2129 Lanesborough Outdoor Theatre
Commons North,
Co. Longford

RESPONSE TO SUBMISSIONS

Request for Further Information

DE BLACAM AND MEAGHER

Drawing file: 318314 / A13 Obscured View Zones- Houses 1 and 2.pdf

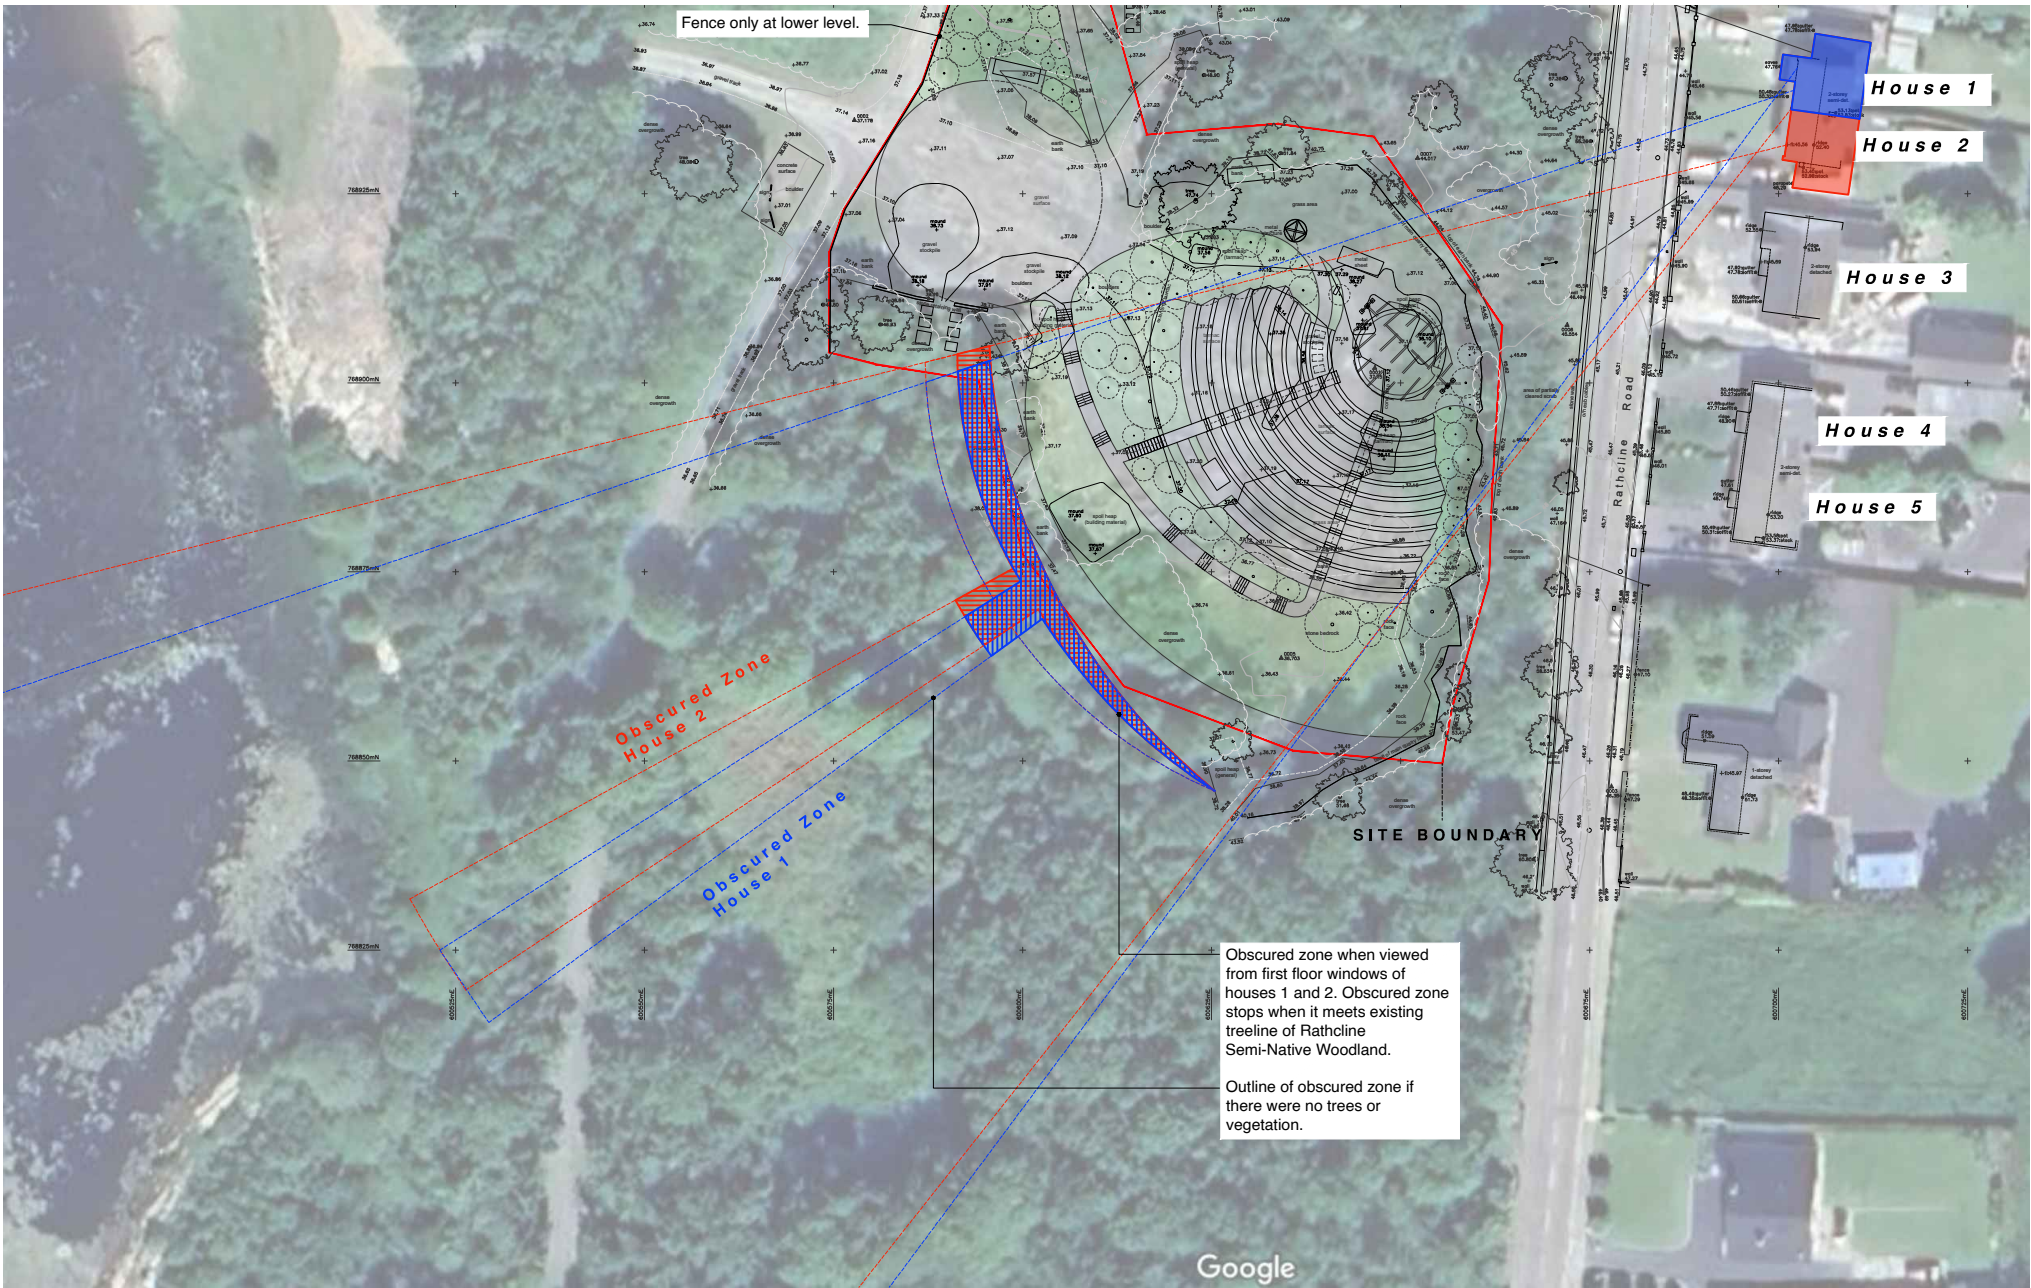
Observation: “The height of the proposed amphitheatre structure is 6 metres plus above ground level with an extensive embankment area at the top. In addition, a proposed sound booth is situated at the top of the structure at a combined height of the 8.5 metres.

1(d). The height and scale of the structure design does not fit seamlessly and respectfully into the landscape. The original proposal was for smaller structure (seating for 200 people).”

Observation: "The tiered seating has a significant rise and going area. This results in an overall structure of unnecessary height that is visible from Rathcline road (including my residence).

The 500mm rise was designed to achieve an adequate quality of view. We propose to lower the rise height to 480mm which is the lowest rise possible before it affects the quality of view as mentioned in 3.2.

1(c). While the upper 2 tiers and sound booth of the amphitheatre will be visible, it will make minimal impact in the overall context of the Rathcline Semi-Native Woodland and Recreation Area. Considering shrubs at the top of the quarry and the woodland below, the impact on views from the property will be minimal in the overall context.

Refer to drawing **A13** in the Appendices.

1(d). The seating area has been revised to reflect the concerns of those who made observations. The 500mm rise was designed to achieve an adequate quality of view. We propose to lower the rise height to 480mm which is the lowest rise possible before it affects the quality of view. The quality of view is determined by using a

An illustration of the zone which will be potentially obscured by the amphitheatre can be found on drawing **A13** in the Appendices.

Response: The seating area has been revised to reflect the concerns of those who made observations. The 500mm rise was designed to achieve an adequate quality of view. We propose to lower the rise height to 480mm which is the lowest rise possible before it affects the quality of view. The quality of view is determined by using a recommended C-value of 90mm (C-value refers to the vertical distance in mm between your line of sight and the eyes of the person in front). Anything lower than 90mm is considered a compromised view. The lowering of the rise height to 480mm would lower the top of the mound and the sound booth by 240mm. The revised seating area height would now be 5760mm above the quarry floor. The top of the sound-booth would be 7390mm above the quarry floor. The impact of these on views from the property are minimal in the overall context.

An illustration of the zone which will be potentially obscured by the amphitheatre can be found on drawing **A13** in the Appendices.
